17 June 2016

RE: SSD 7056 – Remediation, Renewal and Adaptive Re-Use of Campbell's Stores, The Rocks

SSD 7056 – Renewal and Re-use of Campbell’s Stores, The Rocks – City of Sydney comments on Response to Submissions Report

Drawing Title  
**ELEVATIONS**  
JPW Project Number  
12006  
Drawing Status  
EA  
Drawing Number  
EA-A-2000  
Revision  
B

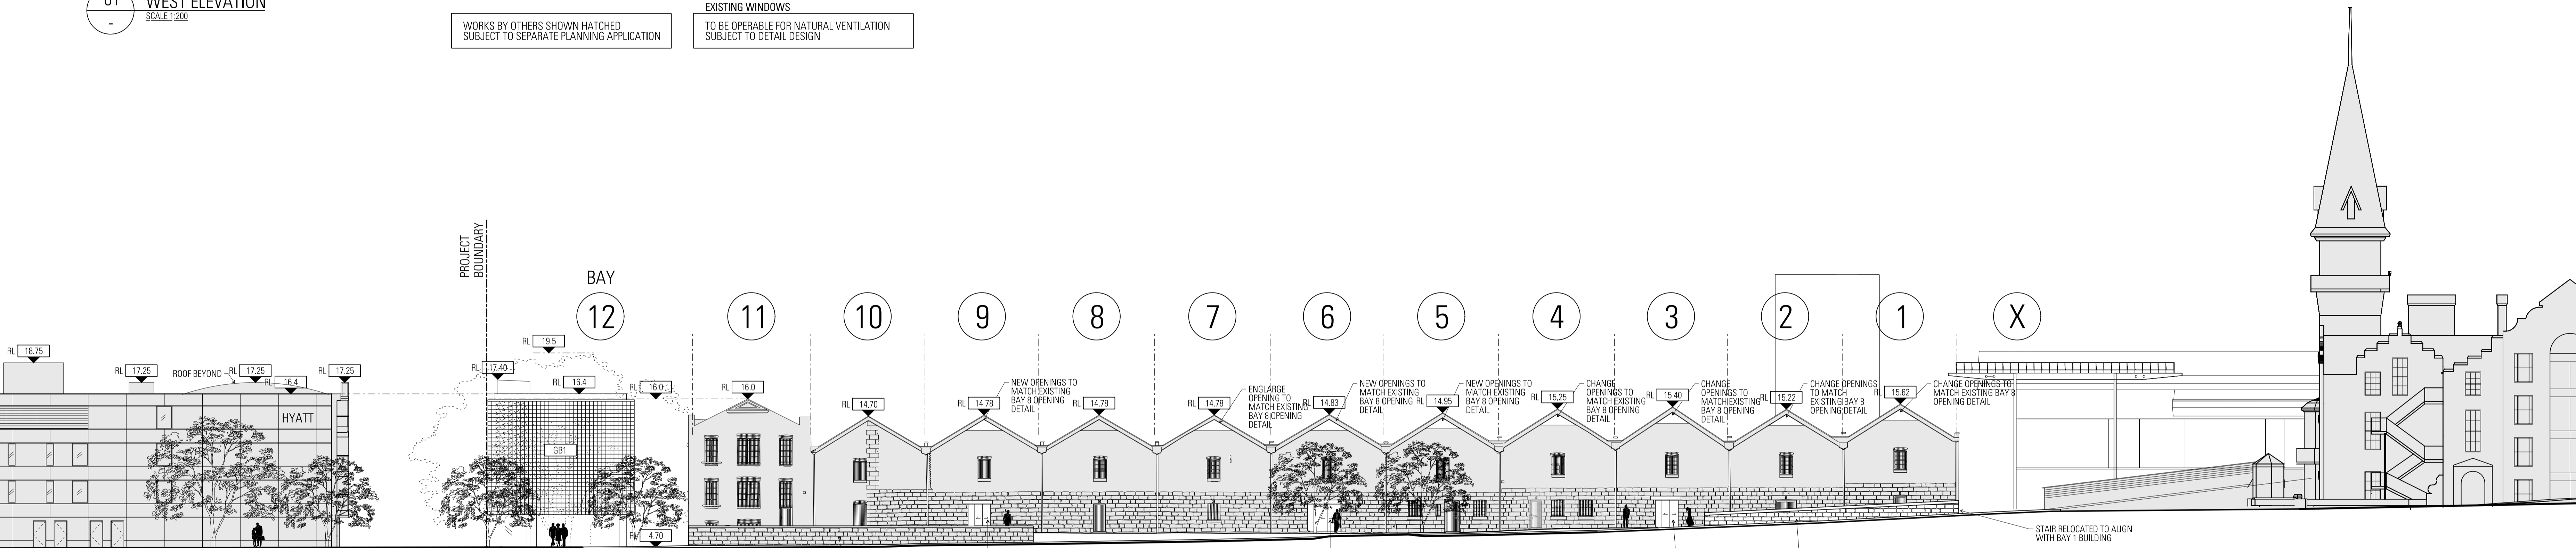
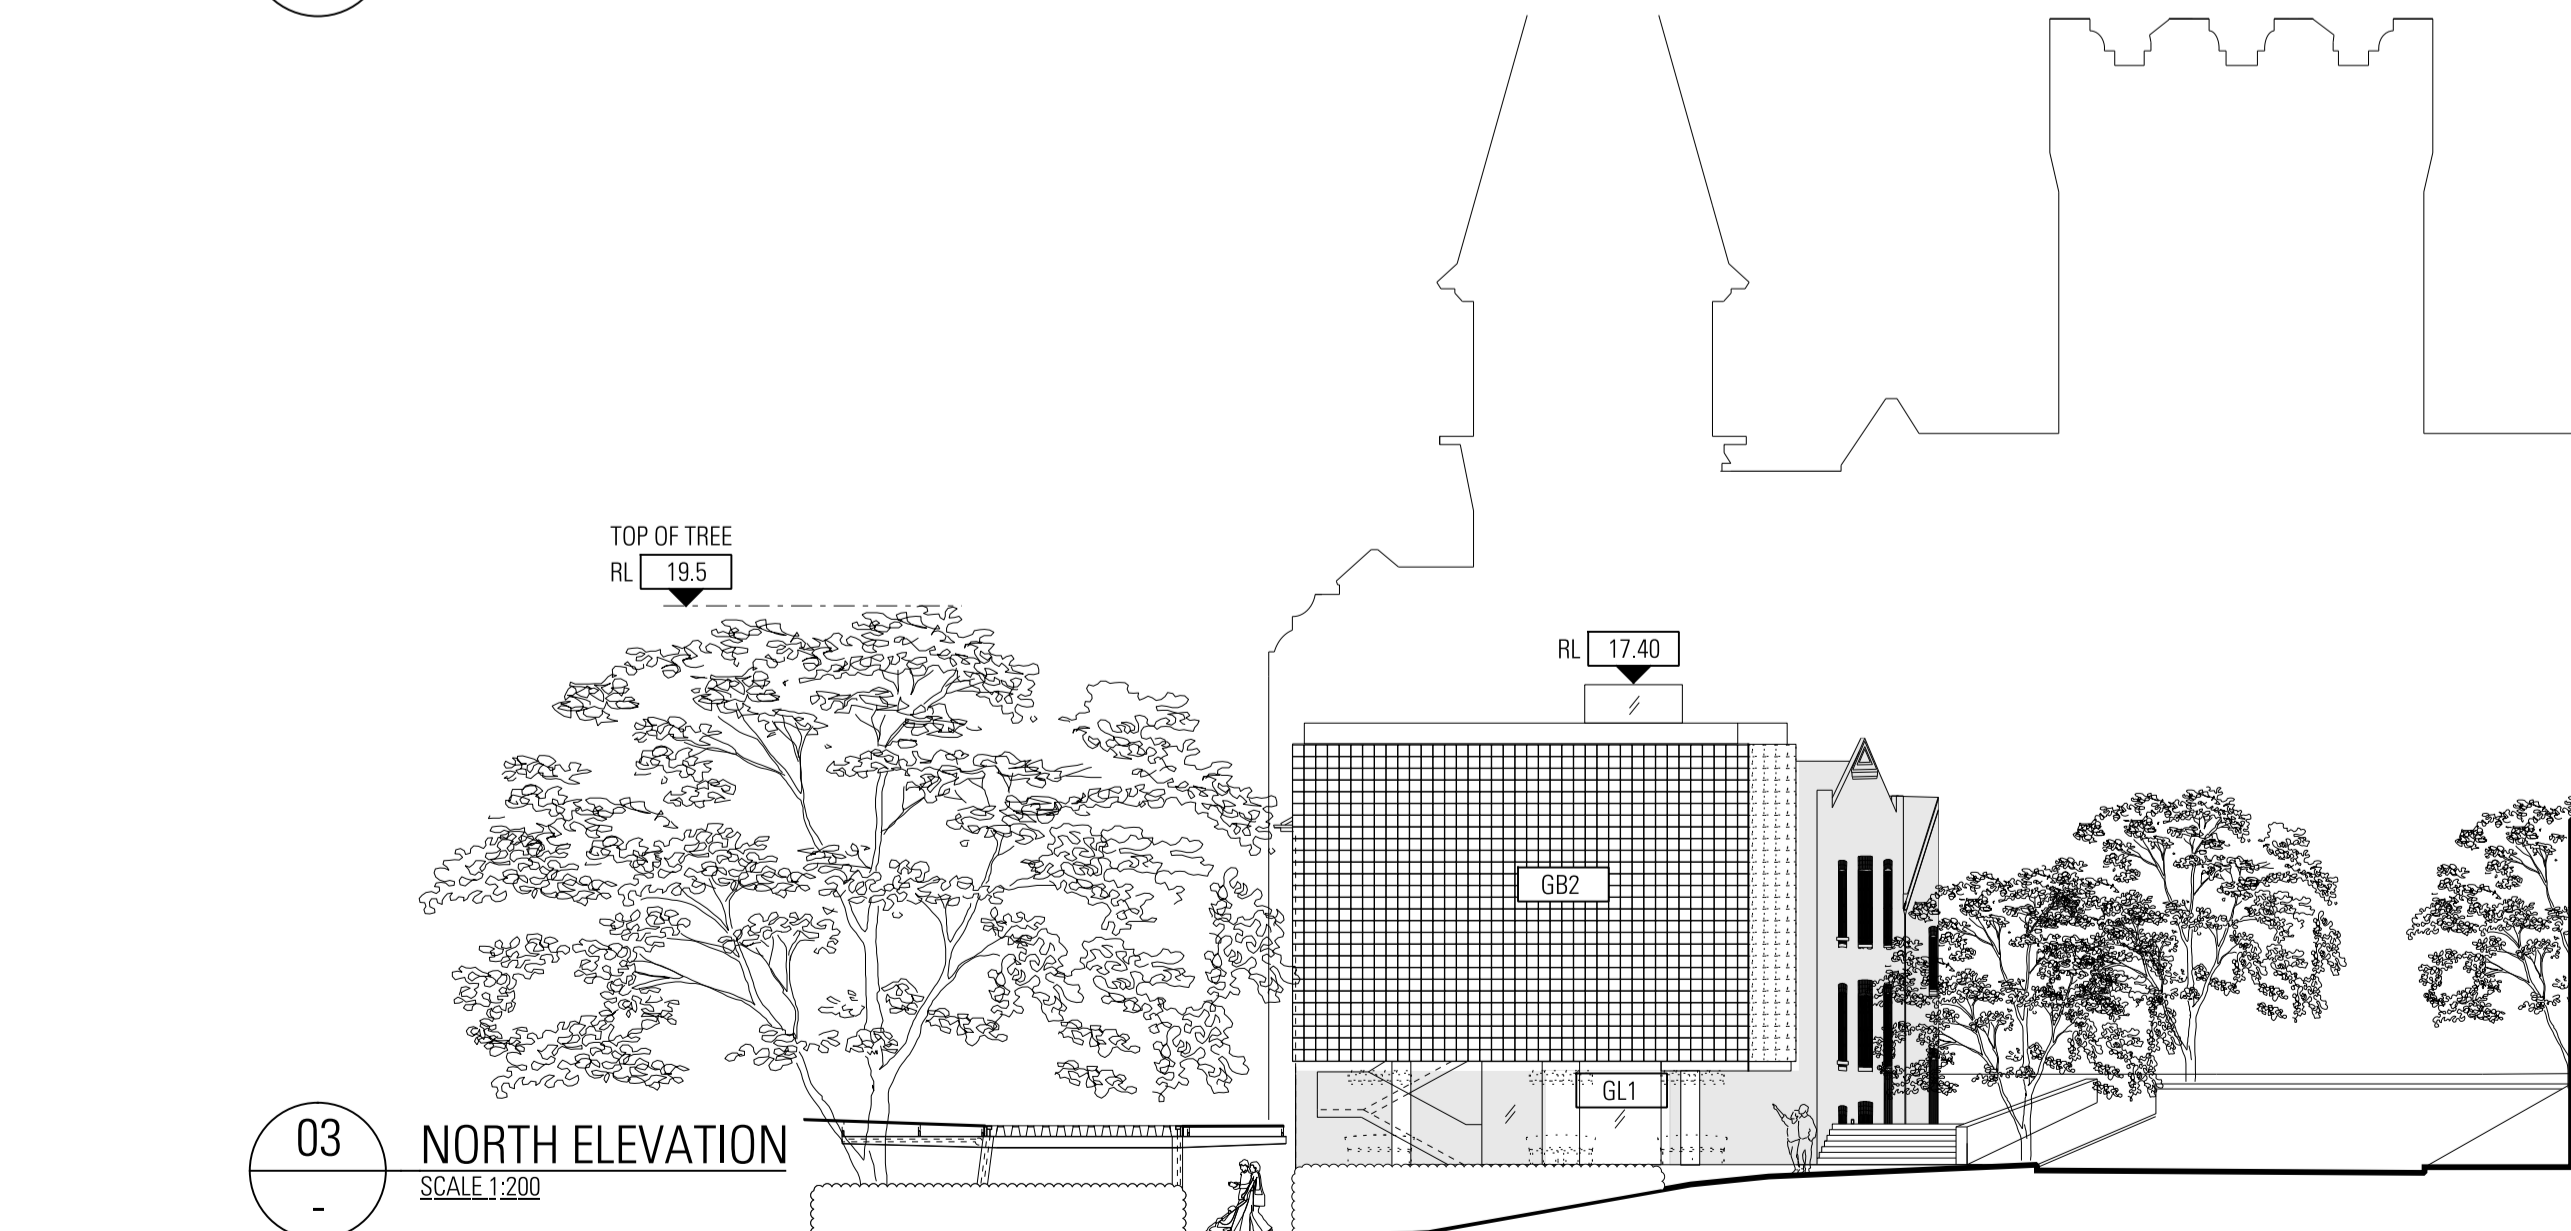
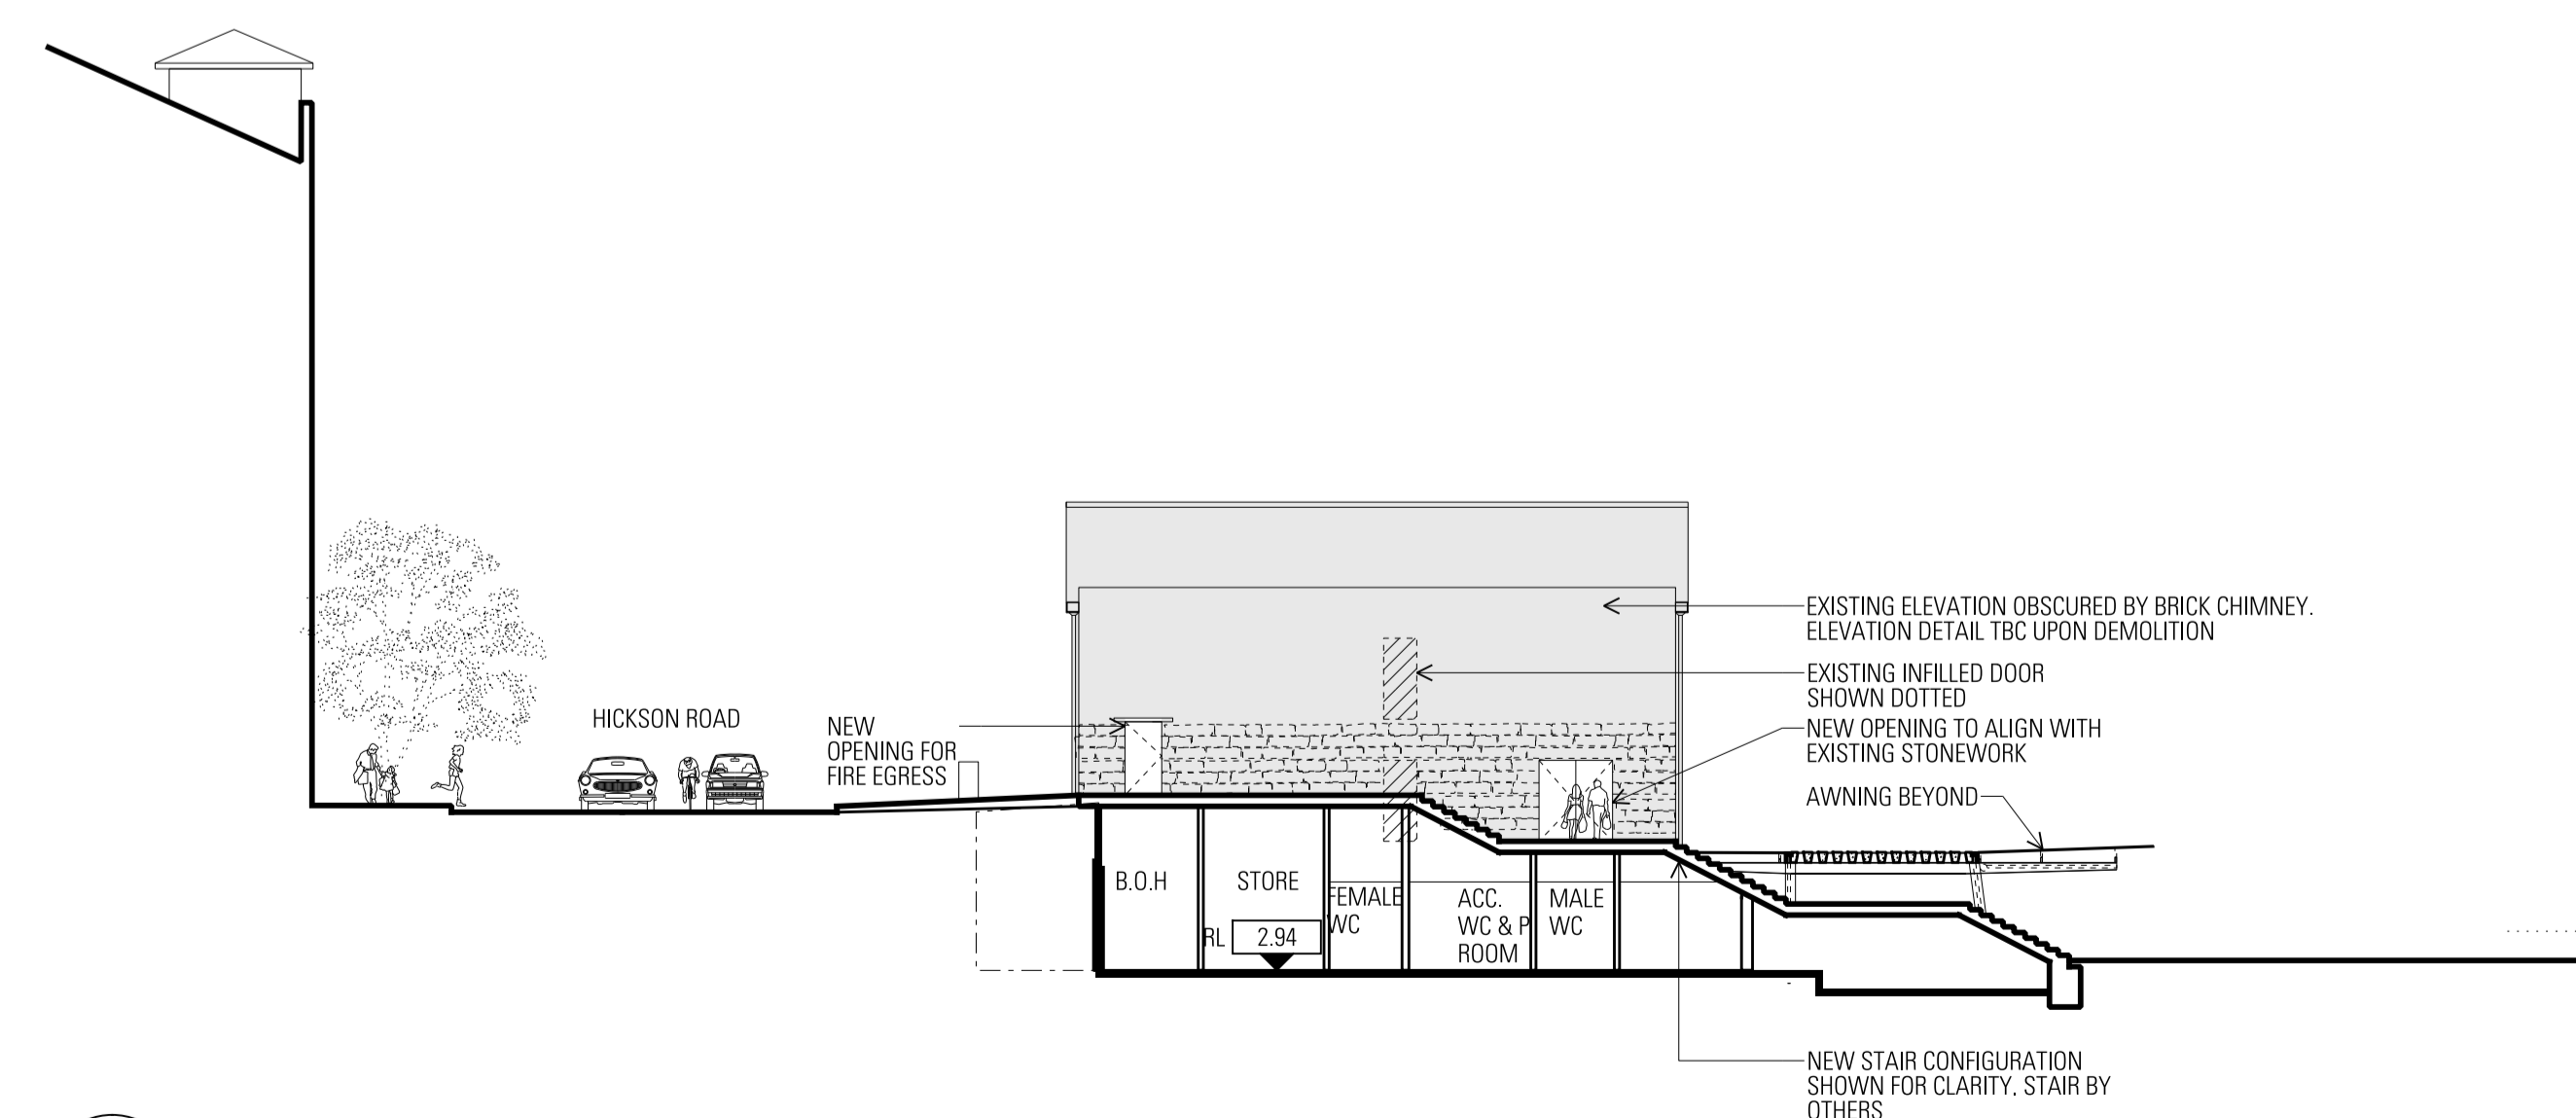
Planning and assessment issues			
Plans, elevations and images are not aligned for the “Bay 12” building. Clarification should be provided.	The design has been clarified. Slot windows have been removed and the drawings modified accordingly.	Yes	No further commentary.
